RE: SSD 15_7267 SUEZ Wetherill Park Transfer Station – development application amendment

- **Amendment 1:** Request the Department of Planning & Environment to provide a transition period prior to the surrender of previous consents to permit construction to occur in parallel to continued operations at the transfer station at our existing tonnage capacity; and
- **Amendment 2:** Removal of the proposed small vehicle drop-off area

01 SITE PLAN

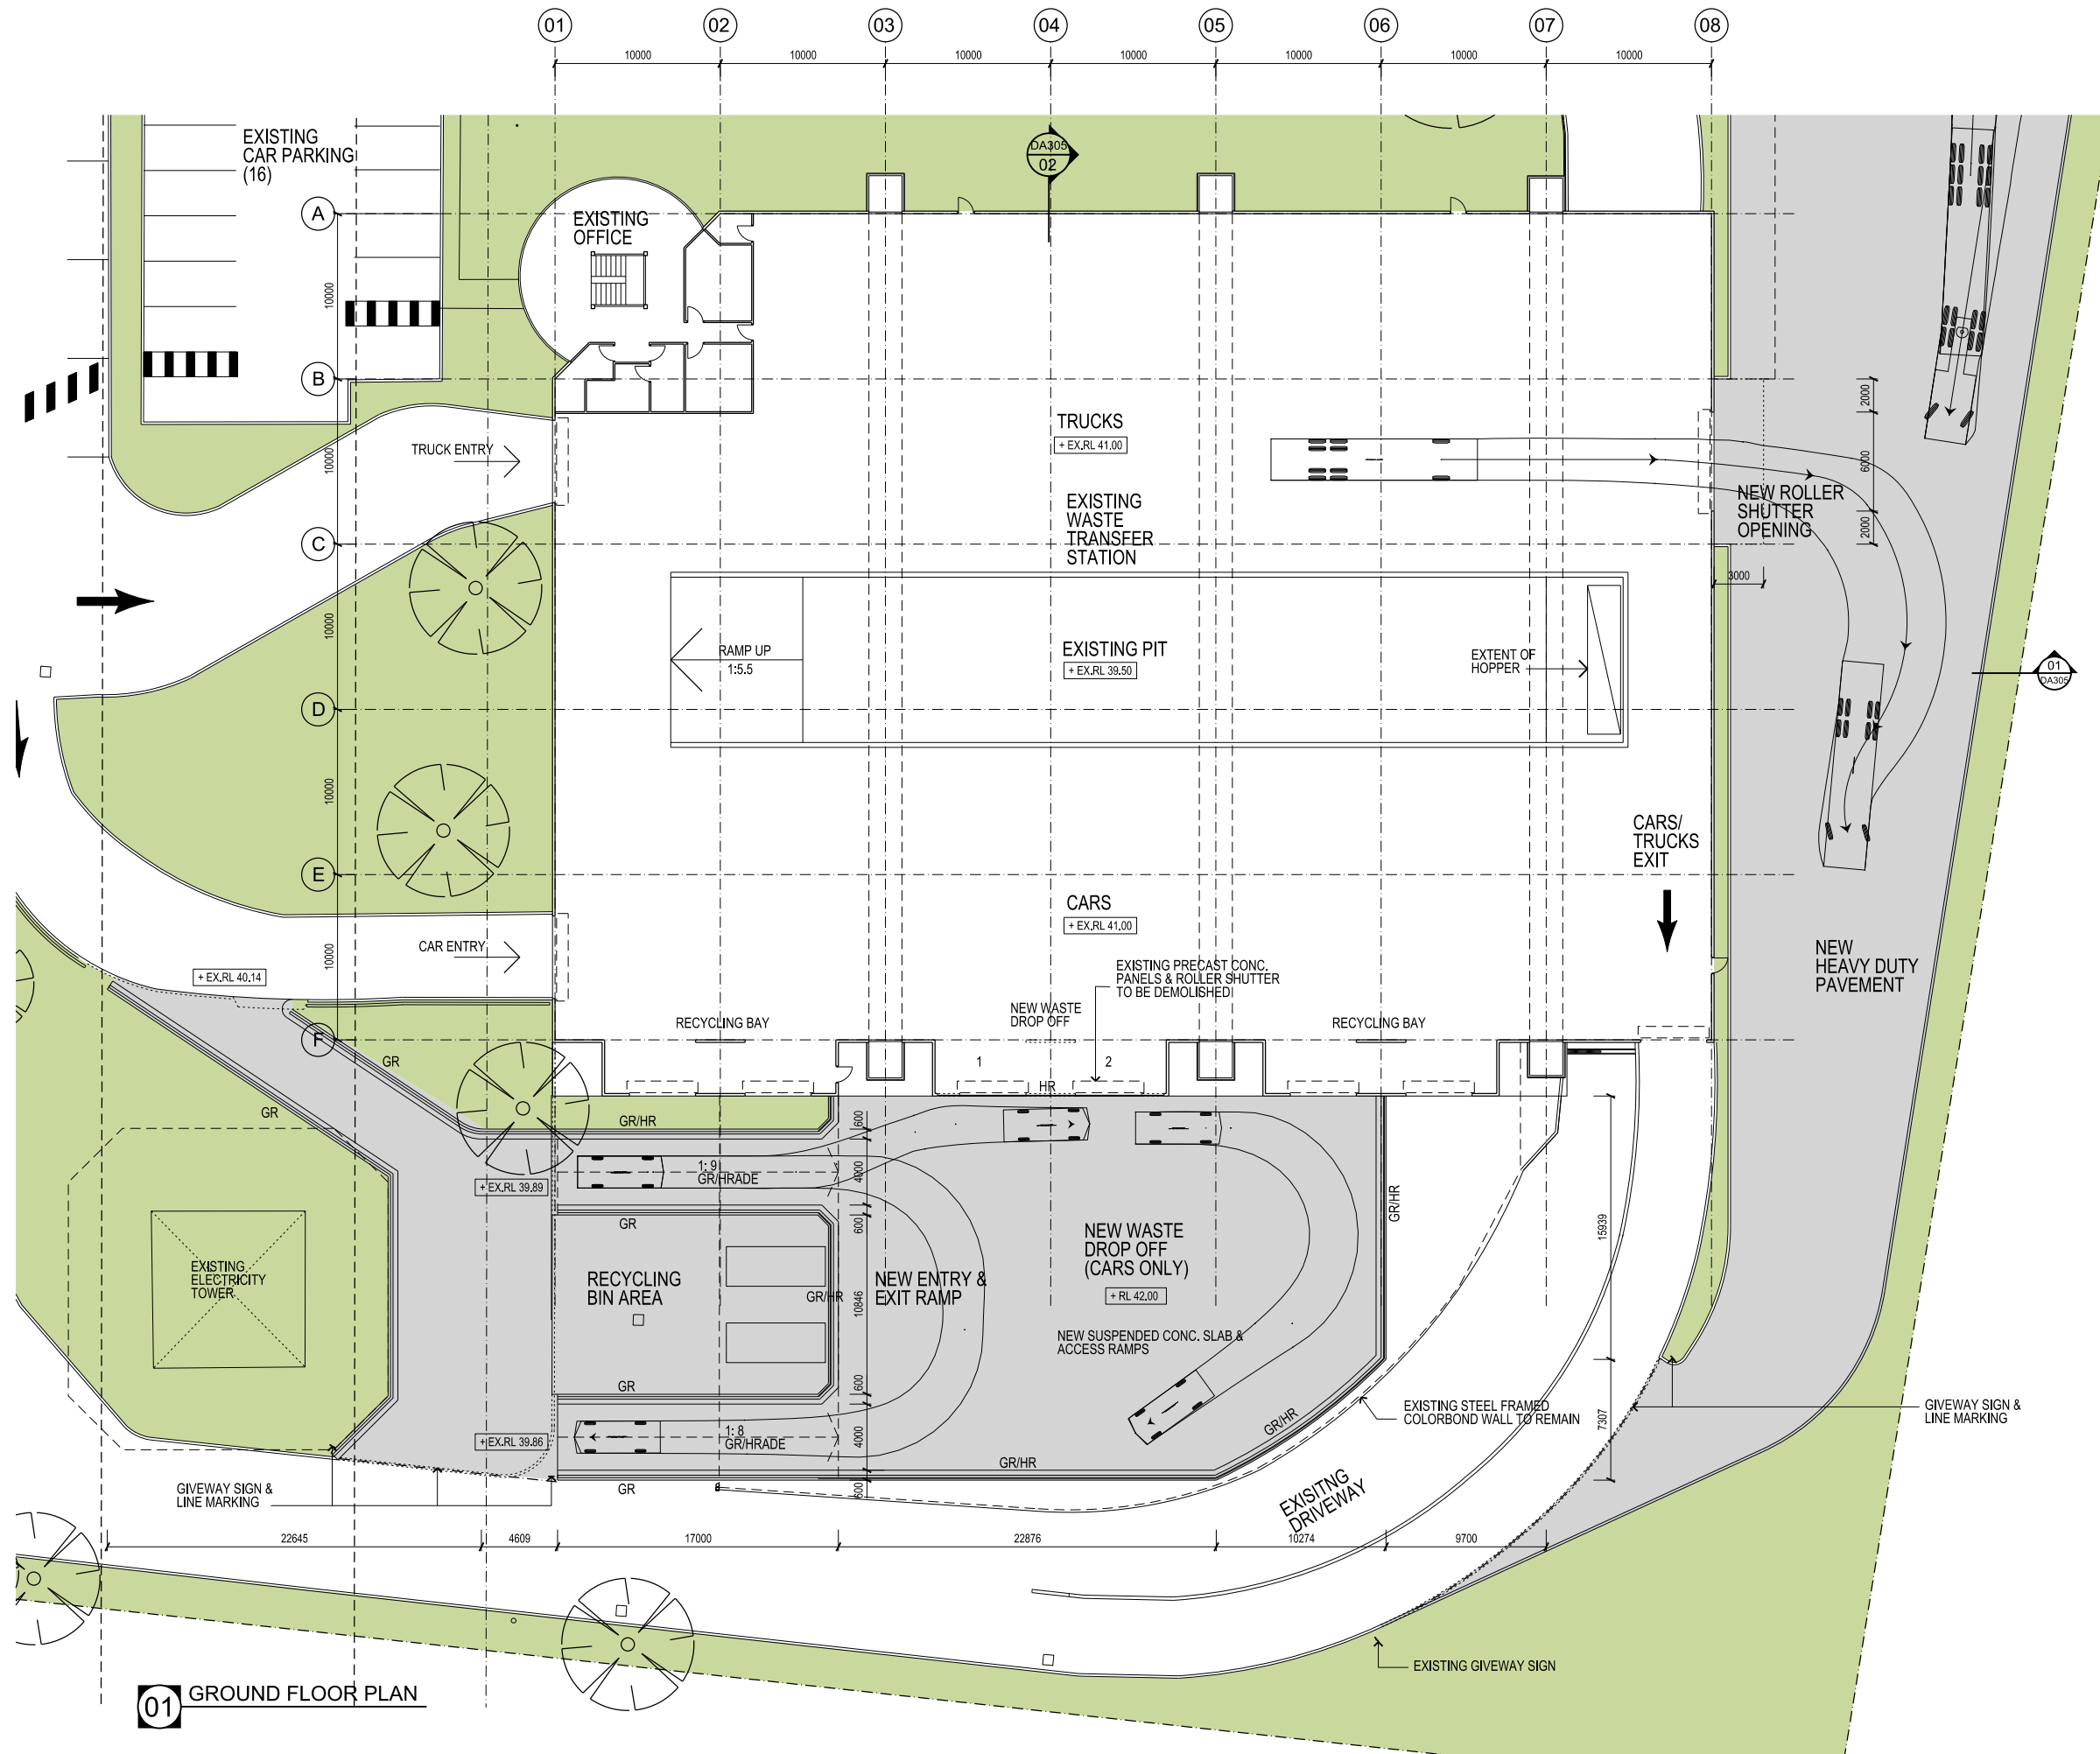
SUEZ's design originally included a small vehicle drop-off area dedicated to manage small vehicles. Upon consideration of TransGrid's comments received 9 June 2017 and subsequent comments received 22 June 2017, SUEZ agreed to modify the plans to remove the proposed small vehicle dropoff area. Copies of the feedback from TransGrid is provided in Attachment A and the updated plans are provided in Attachment B.

As per my previous email to Susan, the design of the driveway to the car dropoff area within TransGrid's easement must comply with TransGrid's requirements outlined in TransGrid's *Easement Guidelines for Third Party Development*. The proposed driveway located 5 metres from TransGrid's structure is not permissible. A driveway will not be approved when located within 20 metres of any part of a transmission line structure.

- There are two components of the proposed works that are currently within the Transgrid easement – the driveway to the proposed trailer parking and the driveway to the proposed small vehicle drop-off area (refer site plan DA101).
- SUEZ understands that as it currently stands the driveway to the small vehicle dropoff area will not be approved by Transgrid as it is within 20m of the transmission line structure.
- We understand all works within the Transgrid easement require Transgrid's assessment and approval, including provision of a 3D DXF file for Transgrid's assessment.

Without the proposed small vehicle dropoff area, SUEZ would continue to manage traffic by separating small and heavy vehicles by having them unload waste from different sides of the surge pit. Further, an additional exit roller door and new heavy duty pavement would be installed at the back of the transfer station which would streamline traffic on site and ensure safety of drivers by minimising interactions between small and heavy vehicles. This would be an improvement over existing traffic flow where the small and heavy vehicles share the same exit door.

The proposed new door at the rear of the transfer station would predominately be used by heavy vehicles, while the small vehicles would exit using the existing opening west of the transfer station building. Initial swept path analysis undertaken as part of developing the concept plans demonstrates there would be adequate space for the heavy vehicles to turn once they exited the transfer station building.

The area designated for the small vehicle drop off area would remain the same as existing and the awning above the area would be retained. The existing stormwater management system has proven capacity to deal with stormwater captured in this area and the removal of the proposed small vehicle dropoff area would not impact the quality or quantity of stormwater currently managed by the system.
